**Lead Local Flood Authority
Post Point CHN 215
Hertfordshire County Council
County Hall, Pegs Lane
HERTFORD SG13 8DN**

Date 17 January 2023

**RE: 6/2022/2220/COND – Stadium Service Station, Stanborough Road, Welwyn
Garden City AL8 6XA**

EXISTING 150DIA COMBINED DRAIN TO PUBLIC SEWER.
DRAIN TO BE FULLY JETTED AND CCTV SURVEY
REQUIRED TO RECORD CONDITION

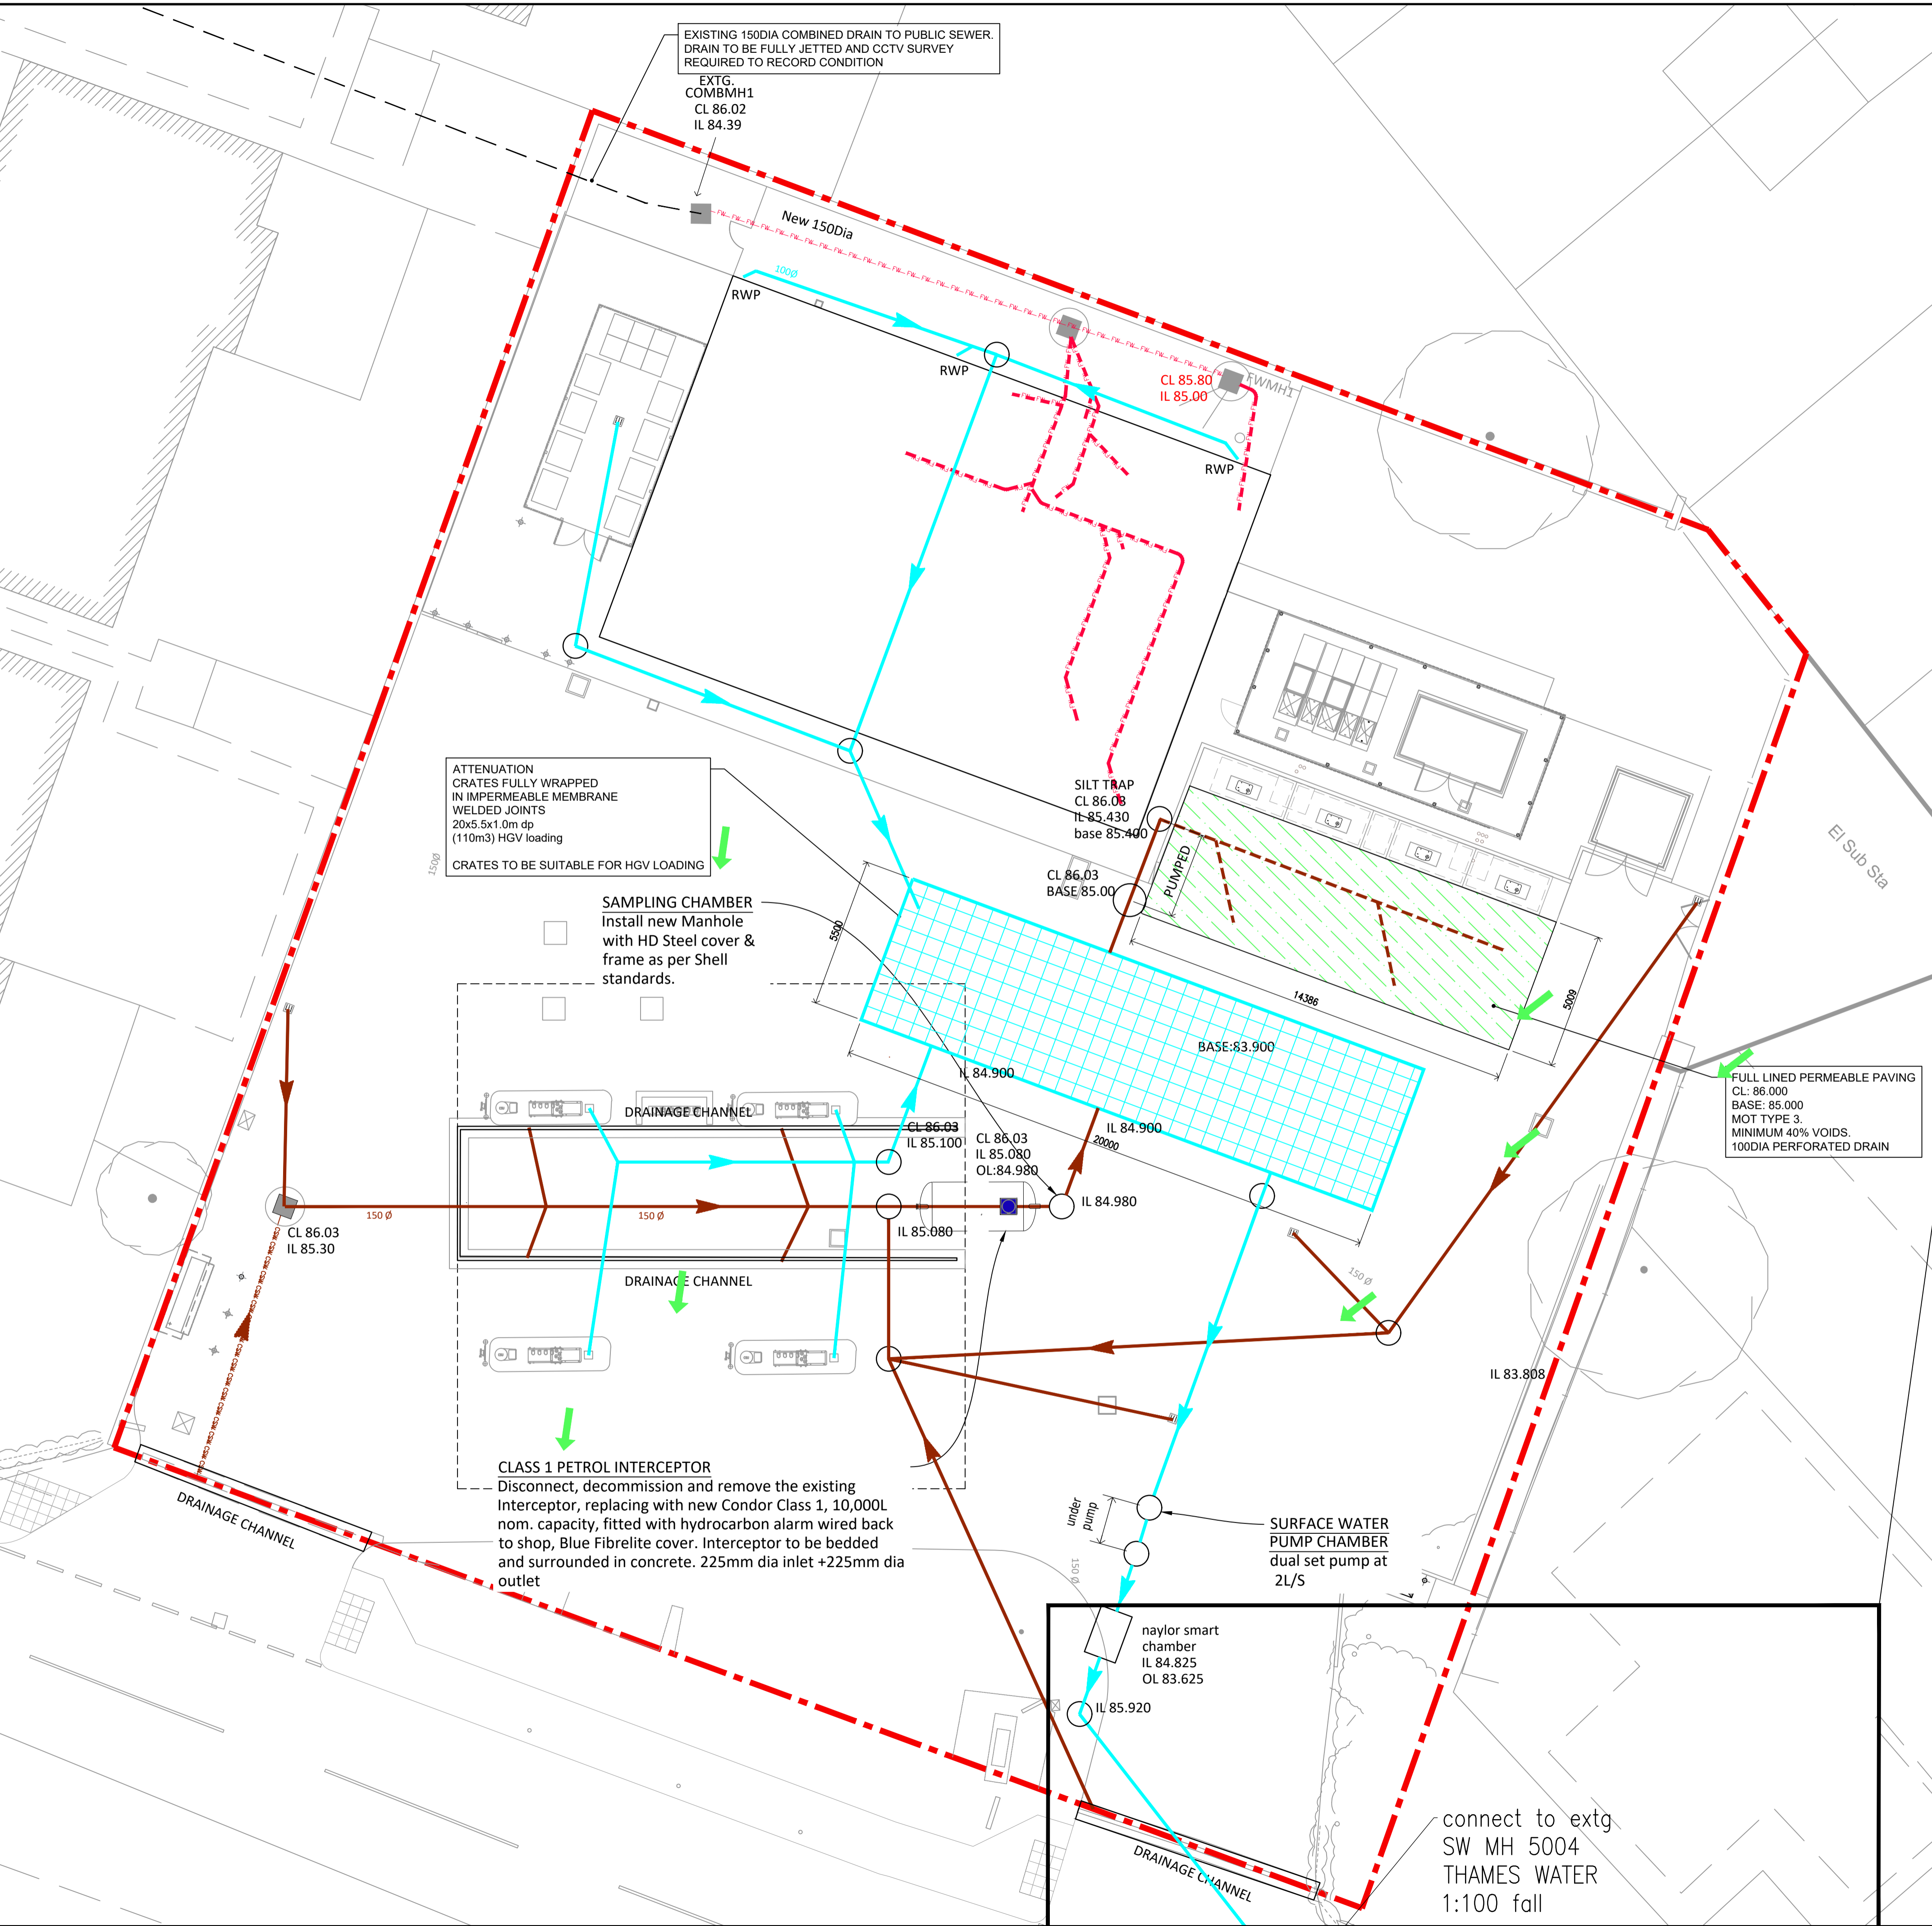
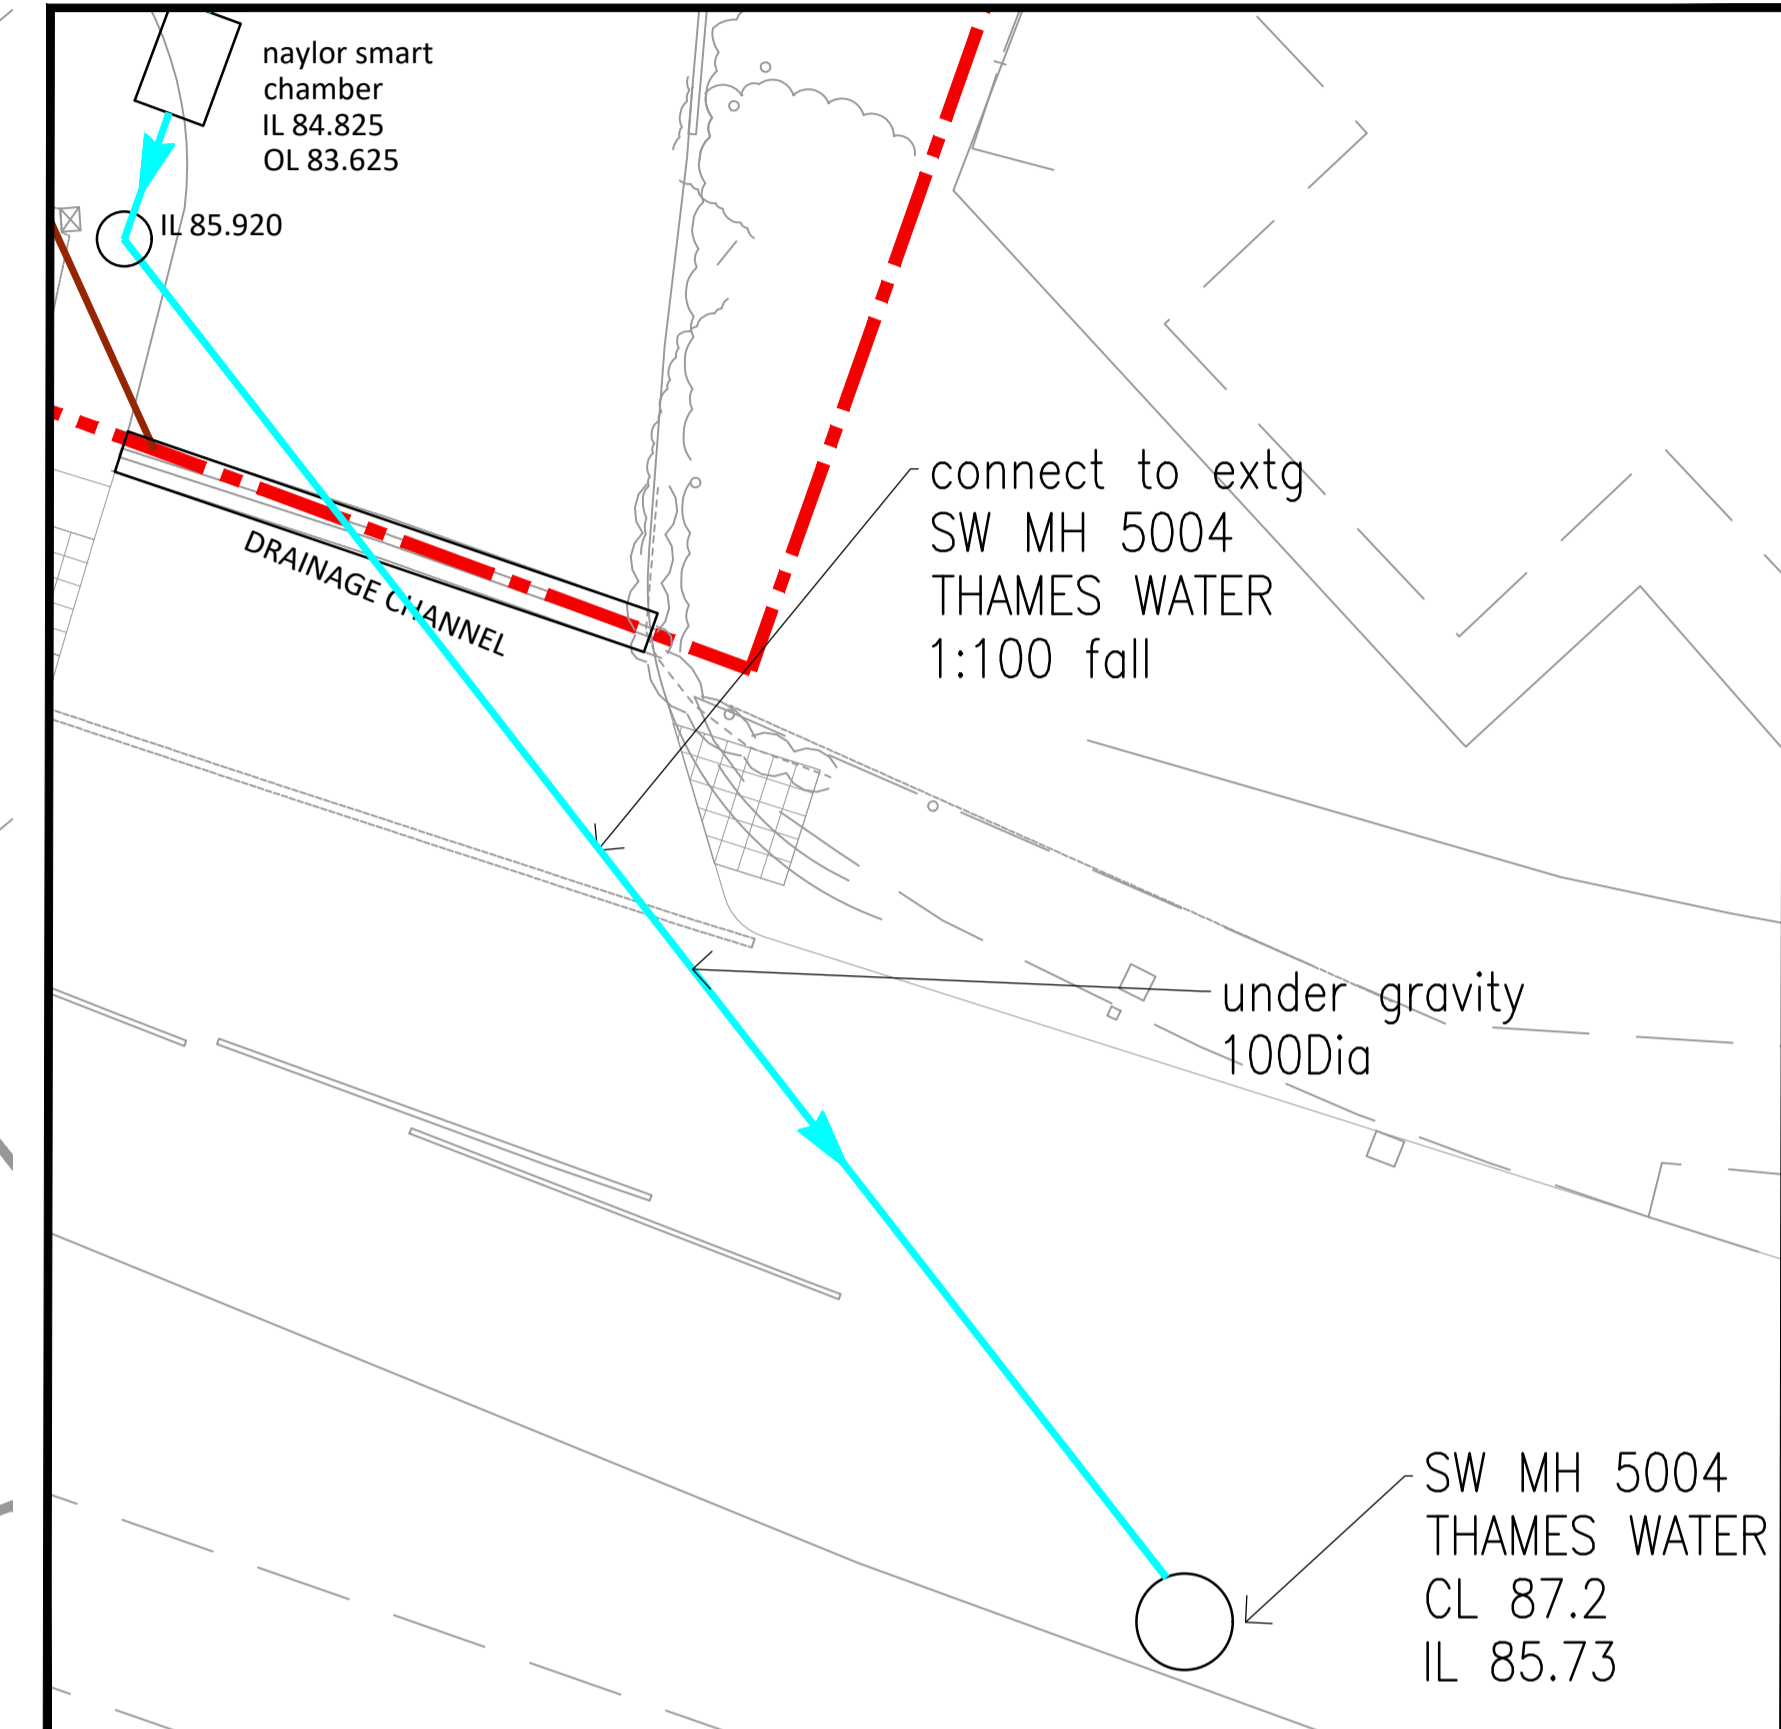
Acknowledging the above, Section 5.3 of the Surface Water Strategy Report indicates that surface water flows will discharge to an existing combined sewer serving the site. However, Section 5.5 onwards and the Drainage Scheme drawing indicates that surface water flows will discharge to an existing public surface water sewer. The LLFA requires clarification on the discharge location for the surface water drainage from the site.

2. The LLFA requests the applicant submits a plan with the modelled drainage network pipe numbers marked on to the proposed drainage plan. This is to provide clarification for the review of the proposed drainage design calculations. For clarification, the drainage plan (Dwg No: H15993-03, Rev: B) should be updated to show the pipe and manhole numbers, pipe lengths, pipe and manhole sizes, pipe gradients and invert/cover levels of all features proposed. . In addition, a detailed engineering drawing of the proposed SuDS (permeable paving, swales, pond) and drainage features must be submitted with the cross section, long section drawings, and plan views with details that include the size, volume, depth and any inlet and outlet levels and feature details.

The LLFA requires a clear plan showing the overland exceedance routes in the event of a failure of the drainage system for exceedance of the 1% AEP event plus 40% climate change. These plans must have the proposed external levels and finished floor levels of all buildings on-site.
